NORWICH TO TILBURY

EN020027

Comments on Submissions received at Deadline 1

12 March 2026

Drawing Number: 10059280-ARC-EGN-ZZ-DR-ZZ-00882
Revision: A

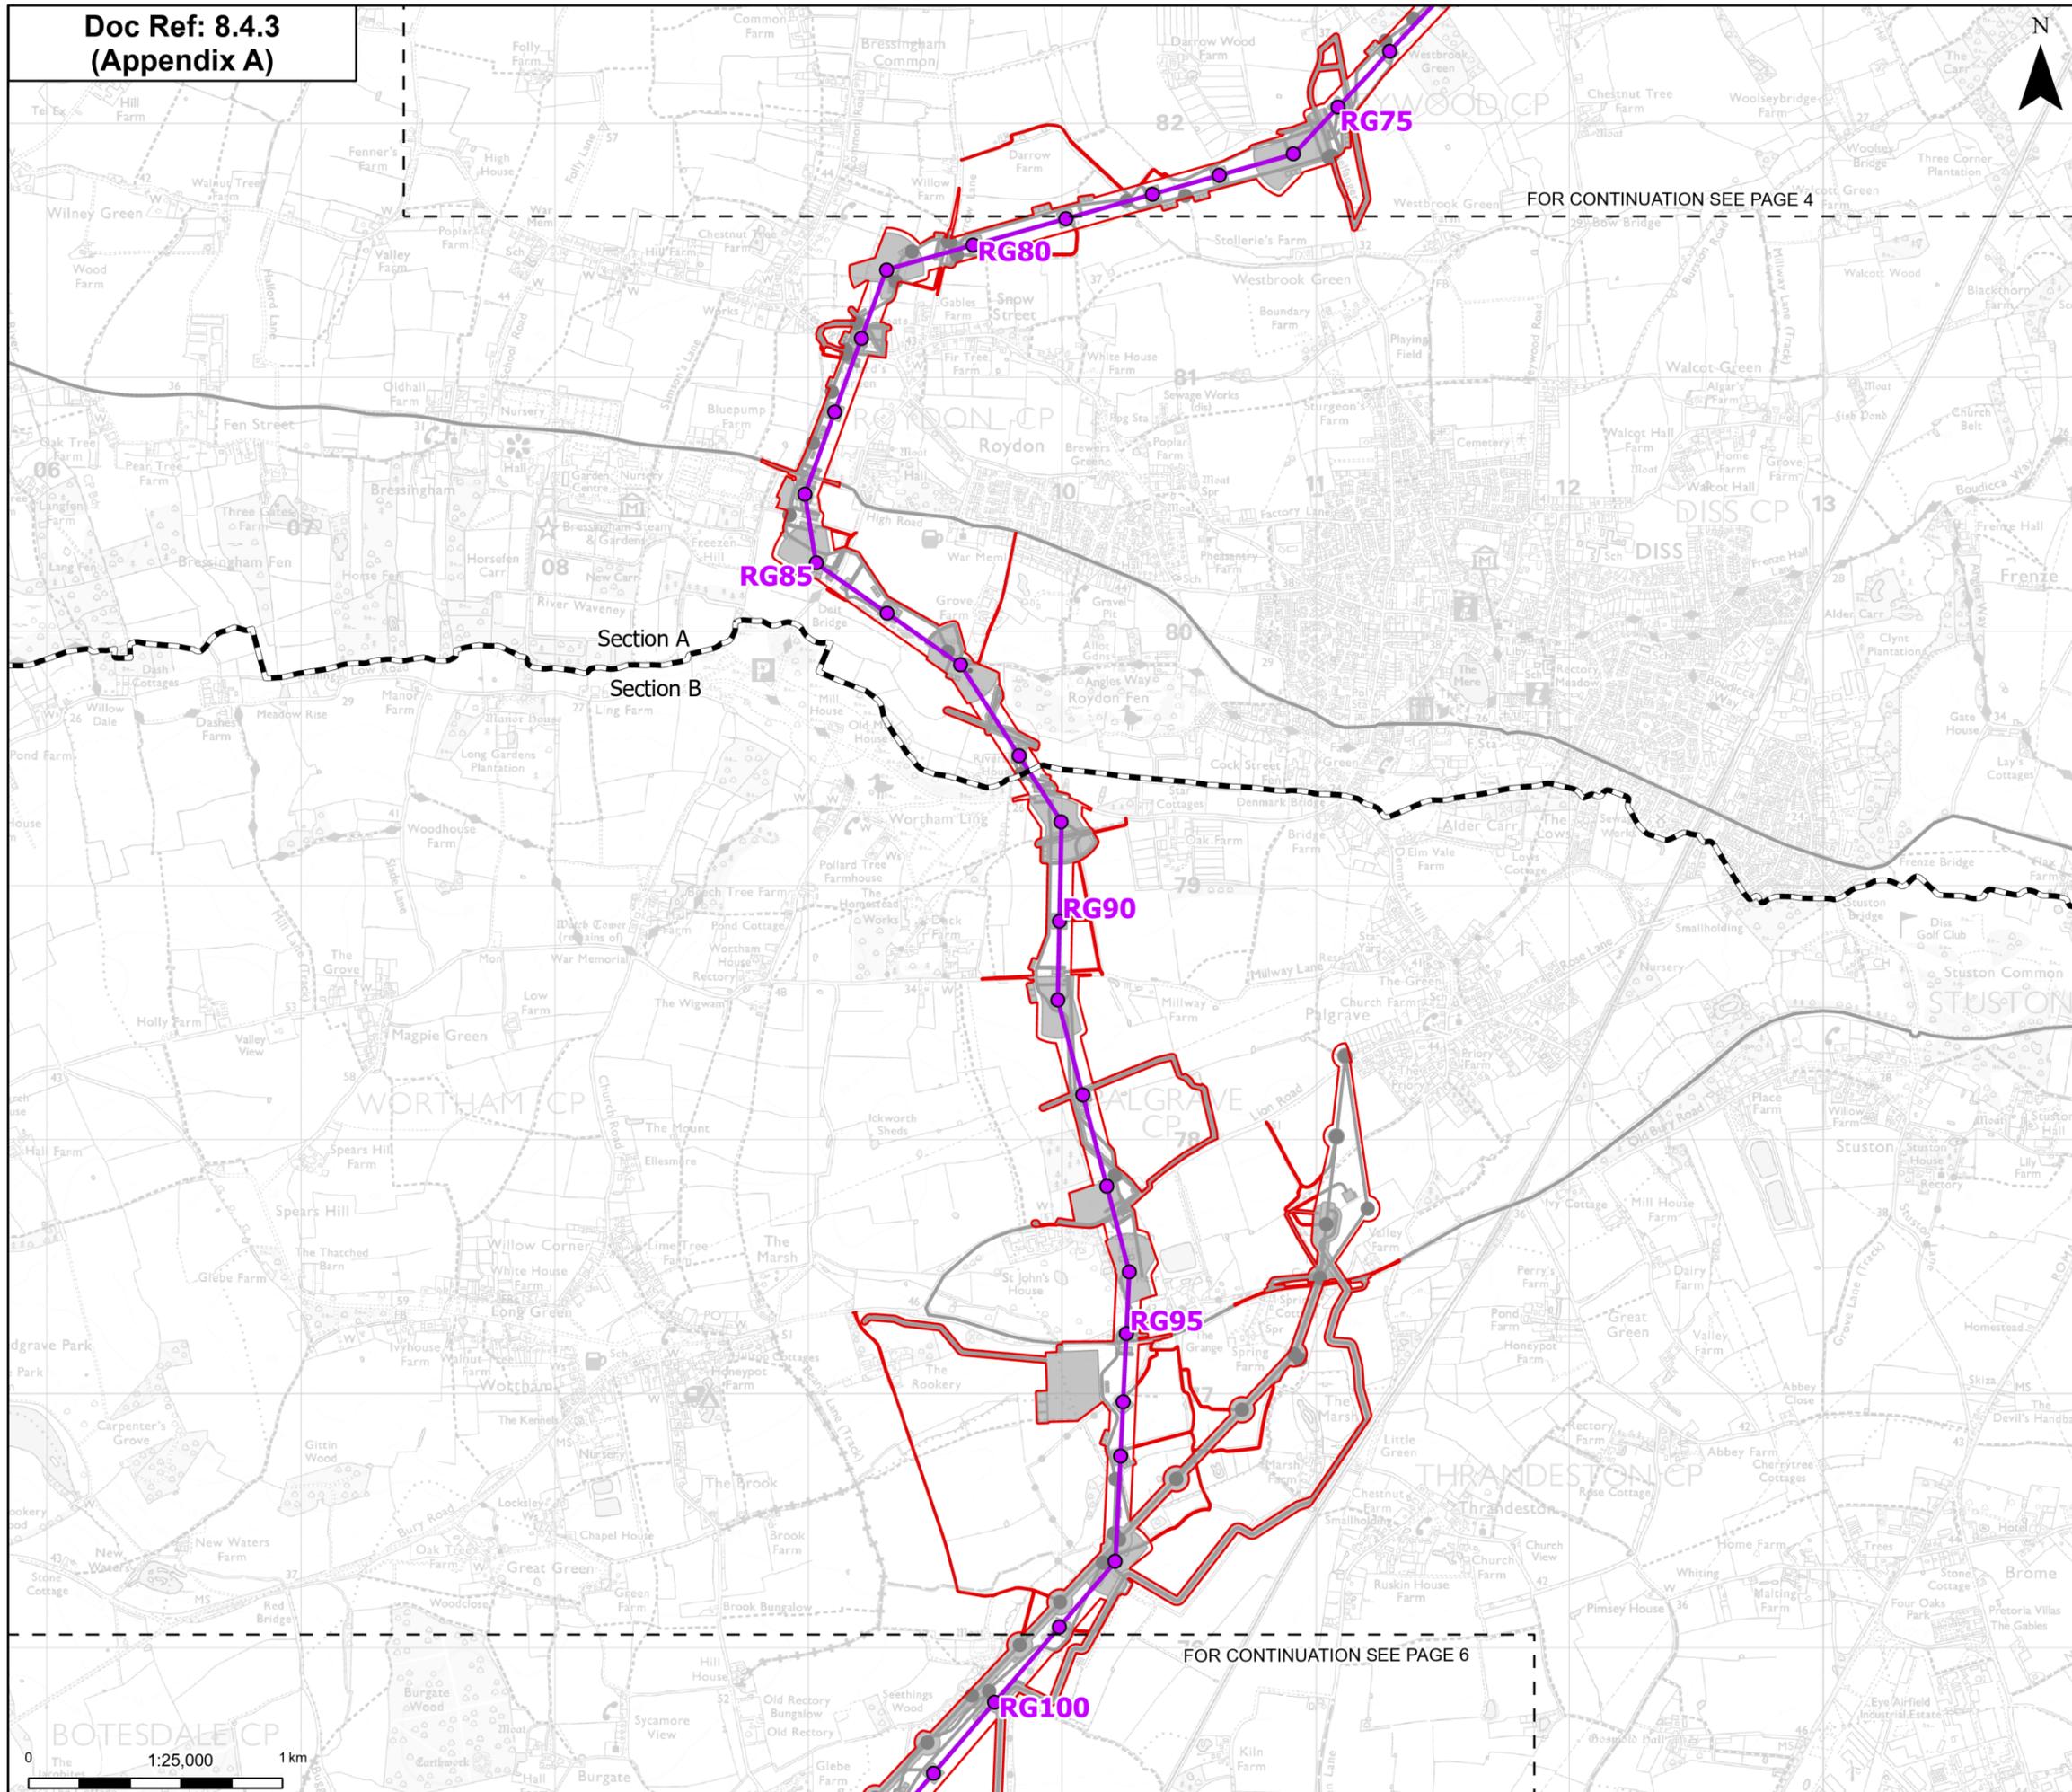
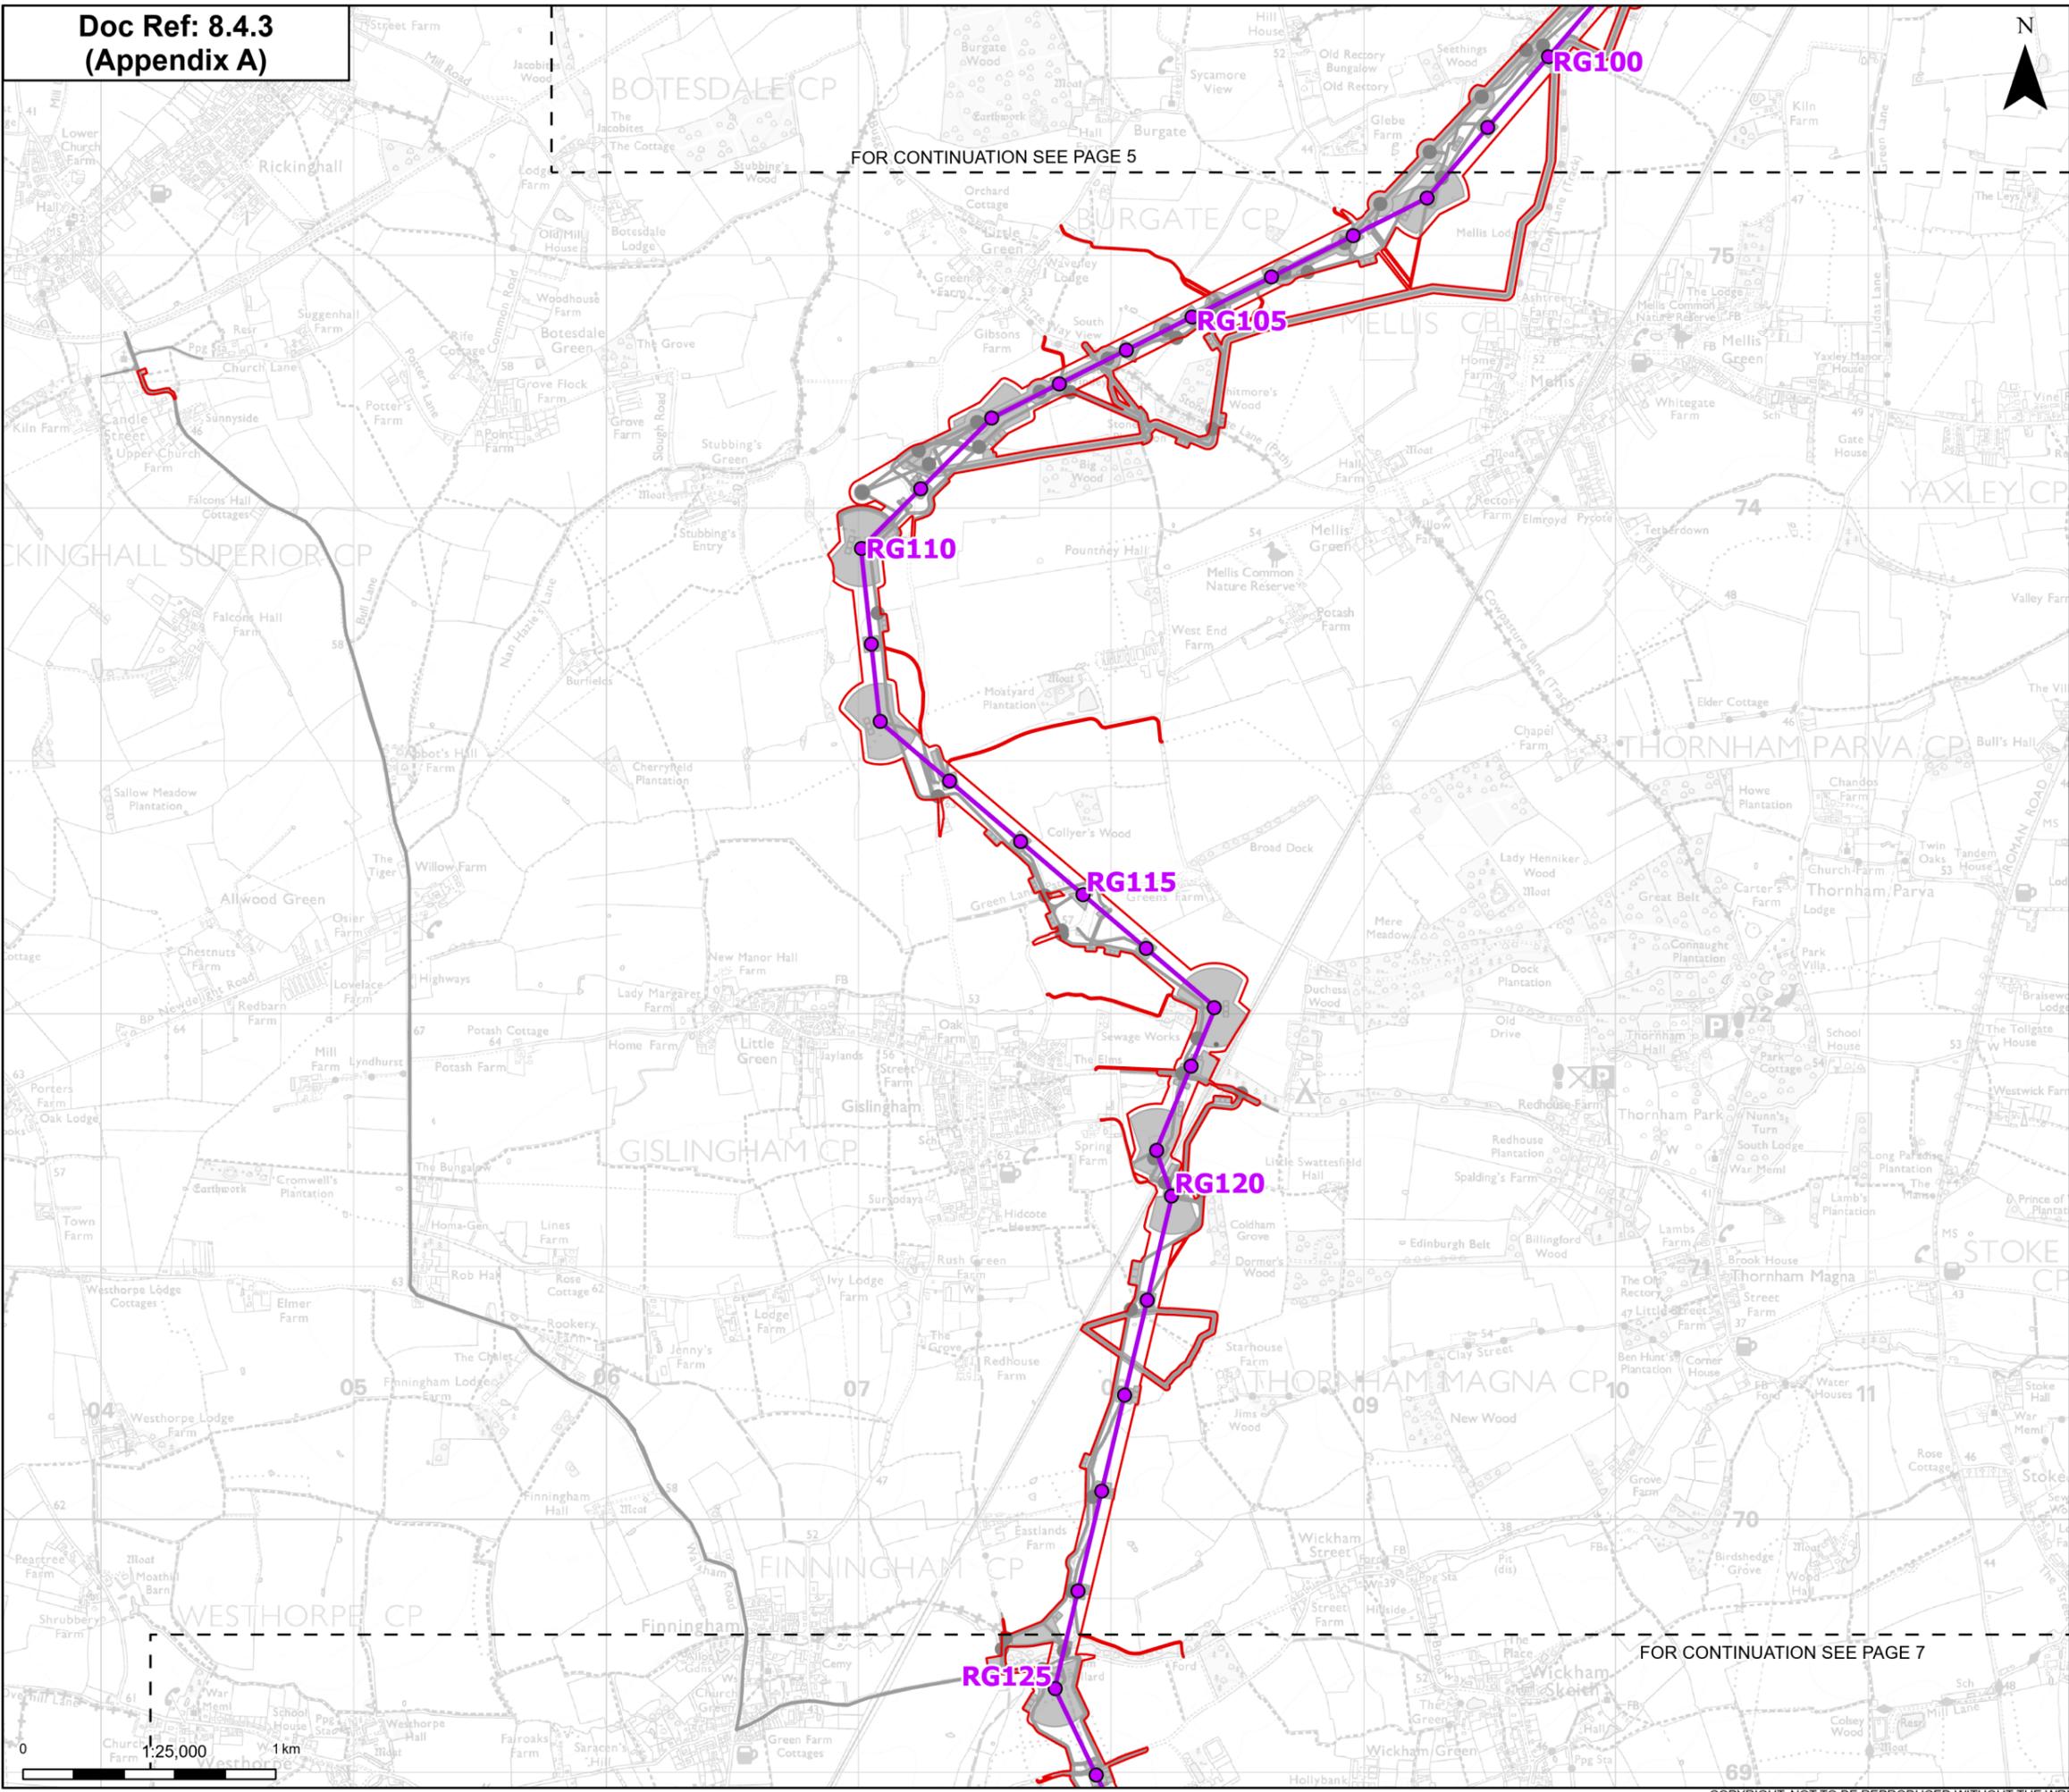
1l	Lead officer	Appendix A	The drafts order limits for the EcoPower Suffolk solar NSIP are not shown
